## ASSESSMENT REPORT

### Block 11 - Central Park, Chippendale SSD 6376 MOD 5

The application has been lodged by Frasers Broadway Pty Ltd (the Applicant) pursuant to section 4.55(1A) of the *Environmental Planning and Assessment Act 1979* (EP&A Act). It seeks approval for the removal of plant equipment on Level 13 to be replaced by 2 x one-bedroom apartments. The modification also seeks approval for several minor internal and external changes.

Figure 3 - Level 13 as approved under SSD 6376 (source: Applicant's EIS)

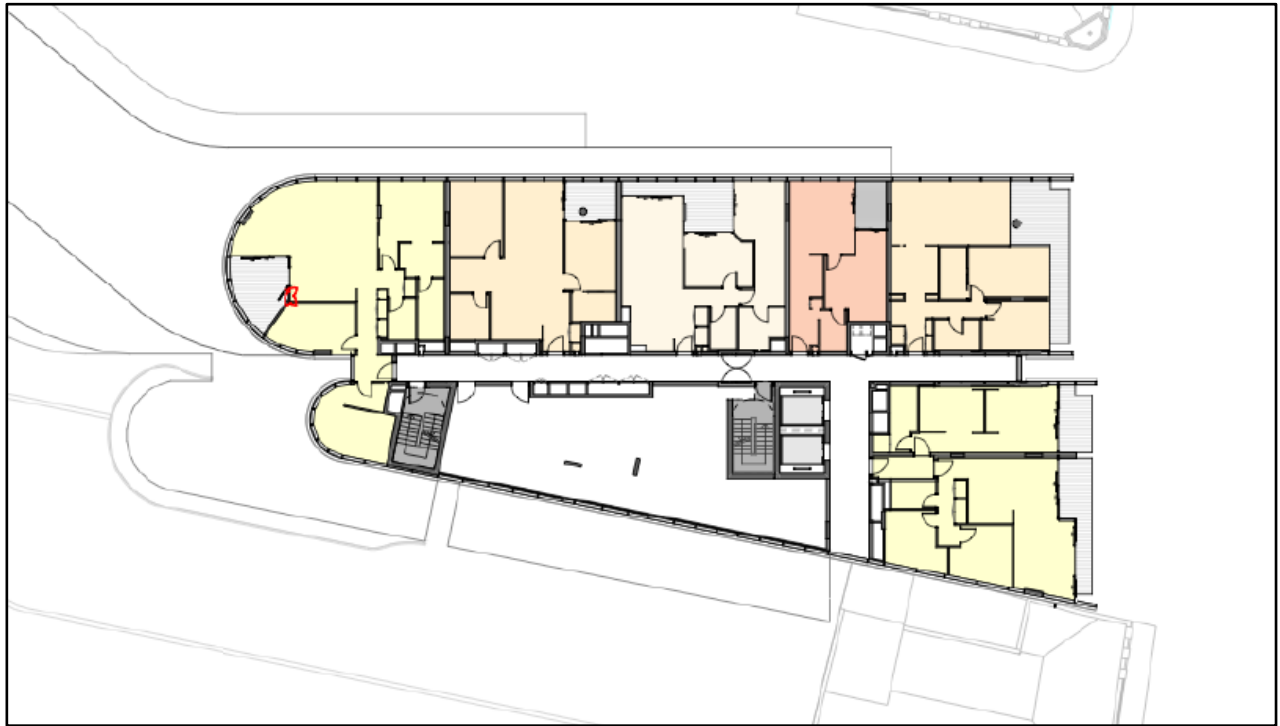
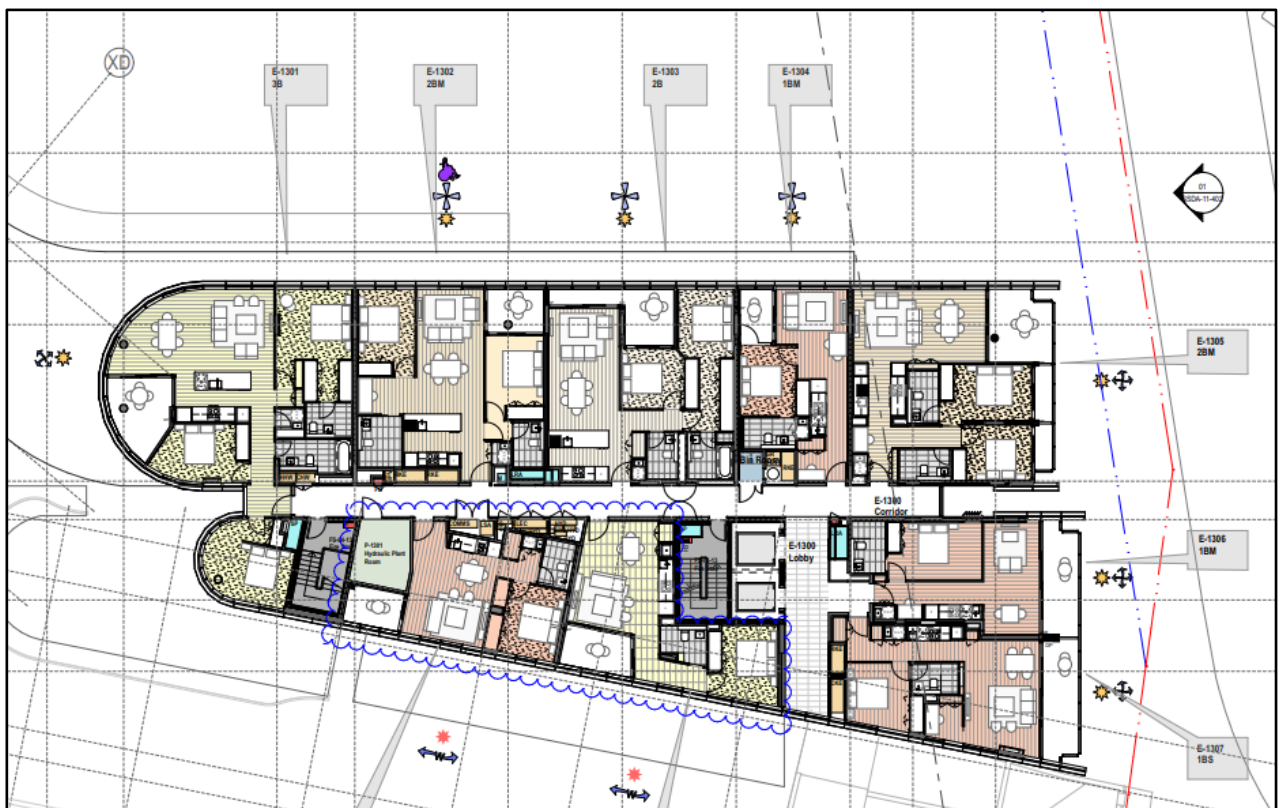
- remove Level 13 plant room services and replace with 2 x one-bedroom units (see **Figures 3 and 4**)
- modify eight units on the northern elevation by replacing loggias with balconies (see **Figures 5 and 6**)
- include additional projecting wall signage above the ground level entry to retail tenancies
- remove internal stairs (stair 5) between Ground Level and Level 1
- make minor internal and external modifications to service and plant structures
- reduce the overall GFA of the building from 25,220 sqm to 25,194 sqm as a result of additional area used for services.

| <i>Issue</i>                                                             | <i>Consideration</i>                                                                                                                                                                                                                                                                                                                                                                                                                                                                                                                                                                                                                                                                                                                                                                                                                                                                                                                                                                                                                                                                                                                                                                                                                                                                                                                       | <i>Recommendation</i>                          |
|--------------------------------------------------------------------------|--------------------------------------------------------------------------------------------------------------------------------------------------------------------------------------------------------------------------------------------------------------------------------------------------------------------------------------------------------------------------------------------------------------------------------------------------------------------------------------------------------------------------------------------------------------------------------------------------------------------------------------------------------------------------------------------------------------------------------------------------------------------------------------------------------------------------------------------------------------------------------------------------------------------------------------------------------------------------------------------------------------------------------------------------------------------------------------------------------------------------------------------------------------------------------------------------------------------------------------------------------------------------------------------------------------------------------------------|------------------------------------------------|
|                                                                          | <ul style="list-style-type: none"> <li>The Applicant notes that a significant portion of the approved plant area on Level 13 was originally intended to accommodate heat rejection equipment for the retail, childcare and community spaces. Most of this area however, is no longer needed because it will be connected to the precinct's central thermal plant which will enable more efficient heating and cooling of the building.</li> <li>The Department considers the proposed modification to Level 13 is acceptable as it would not change the height, bulk or scale of the approved building and it would not result in any adverse environmental impacts on adjoining neighbours. Further, the connection of the building to the precinct's central thermal plant will enable more efficient heating and cooling of the building, improving its sustainability.</li> </ul>                                                                                                                                                                                                                                                                                                                                                                                                                                                      | amendments necessary.                          |

Figure 3- Proposed retail signage to ground floor – northern elevation looking south down Kensington Street

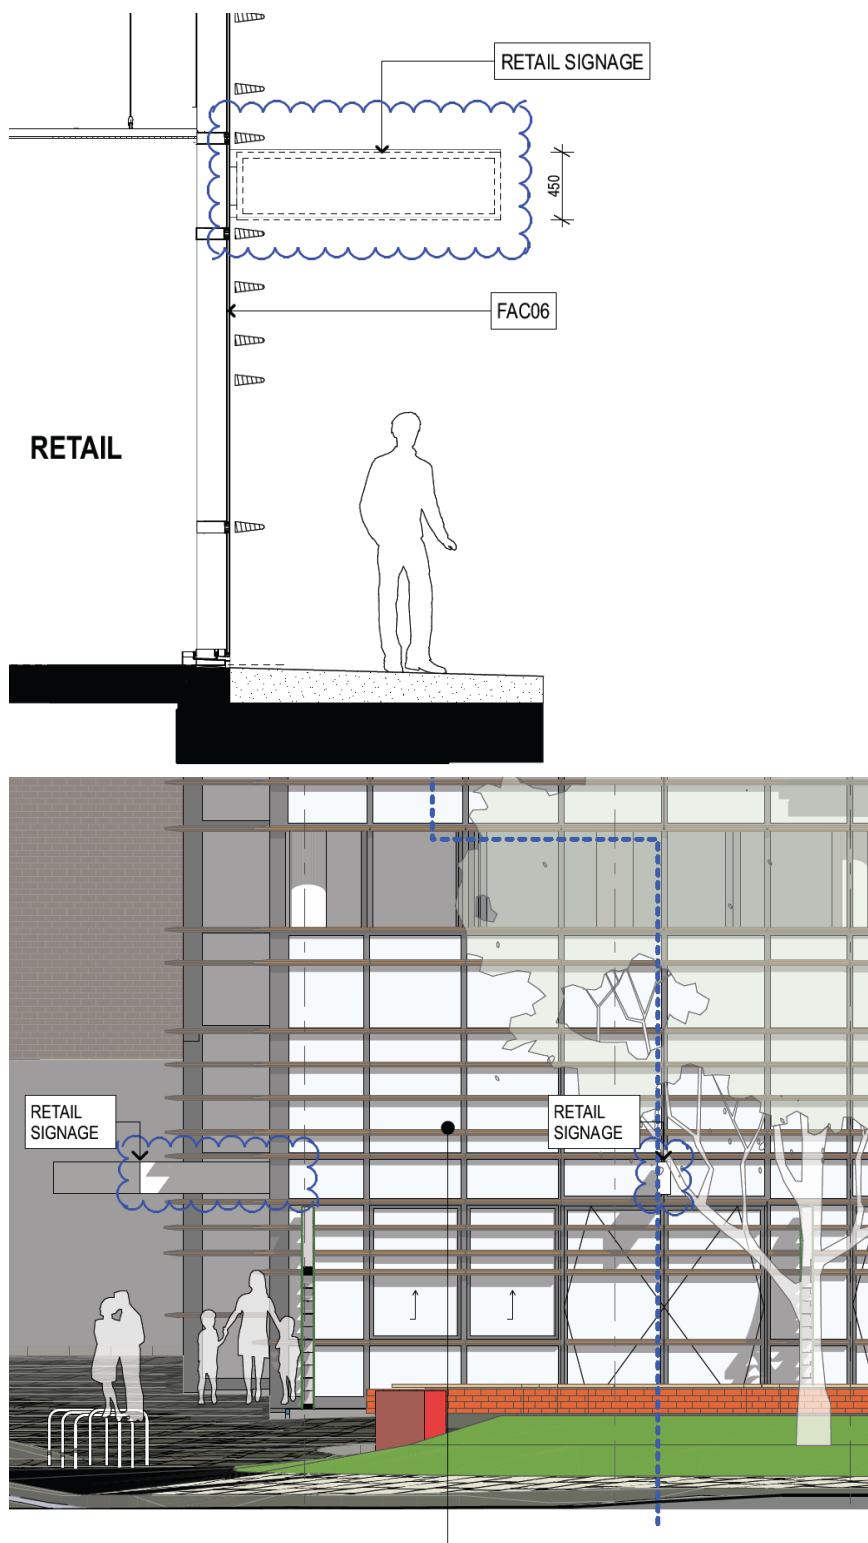
- the addition of two apartments is suitable as there is no increase in overall building height
- the proposed projecting signage should be reduced in size (to be less than 0.5 m<sup>2</sup>) and elevated to 2.6 m above ground level to comply with Council's signage guidelines.

| <i>Issue</i>                                                             | <i>Consideration</i>                                                                                                                                                                                                                                                                                                                                                                                                                                                                                                                                                                                                                                                                                                                                                                                                                                                                                                                                                                                                                                                                                                                                                                                                                                                                                                                       | <i>Recommendation</i>                          |
|--------------------------------------------------------------------------|--------------------------------------------------------------------------------------------------------------------------------------------------------------------------------------------------------------------------------------------------------------------------------------------------------------------------------------------------------------------------------------------------------------------------------------------------------------------------------------------------------------------------------------------------------------------------------------------------------------------------------------------------------------------------------------------------------------------------------------------------------------------------------------------------------------------------------------------------------------------------------------------------------------------------------------------------------------------------------------------------------------------------------------------------------------------------------------------------------------------------------------------------------------------------------------------------------------------------------------------------------------------------------------------------------------------------------------------|------------------------------------------------|
| <i>Ground Level Retail Tenancies Signage</i>                             | <ul style="list-style-type: none"> <li>The proposal seeks approval for five projecting wall signs on the Ground Level above the retail tenancies. The signage will comprise illuminated light boxes affixed to the retail tenancy façades. The proposed signs are 450 mm high and 1750 mm wide.</li> <li>Council has expressed concern that the proposed signage does not comply with its signage guidelines. To achieve compliance, Council requires the proposed signage to project no more than one metre from the façade, be elevated to 2.6 m above the ground level of the footpath and be less than 0.5 m<sup>2</sup> in area.</li> <li>The Applicant notes that indicative signage zones were approved under SSD 6376 and the proposed signage is consistent with other signage in the Central Park precinct.</li> <li>However, the Department notes Condition A6 states that the consent does not approve signage and 'separate approval/s for the fit out of the building and signage to be obtained for this development/use if required by the EP&amp;A Act'.</li> <li>Accordingly, the consent cannot be modified to include signage as it was not approved in the original application. As such, the Applicant will need separate approval/s for the signage in accordance with the requirements of Condition A6.</li> </ul> | No additional comments or amendments necessary |
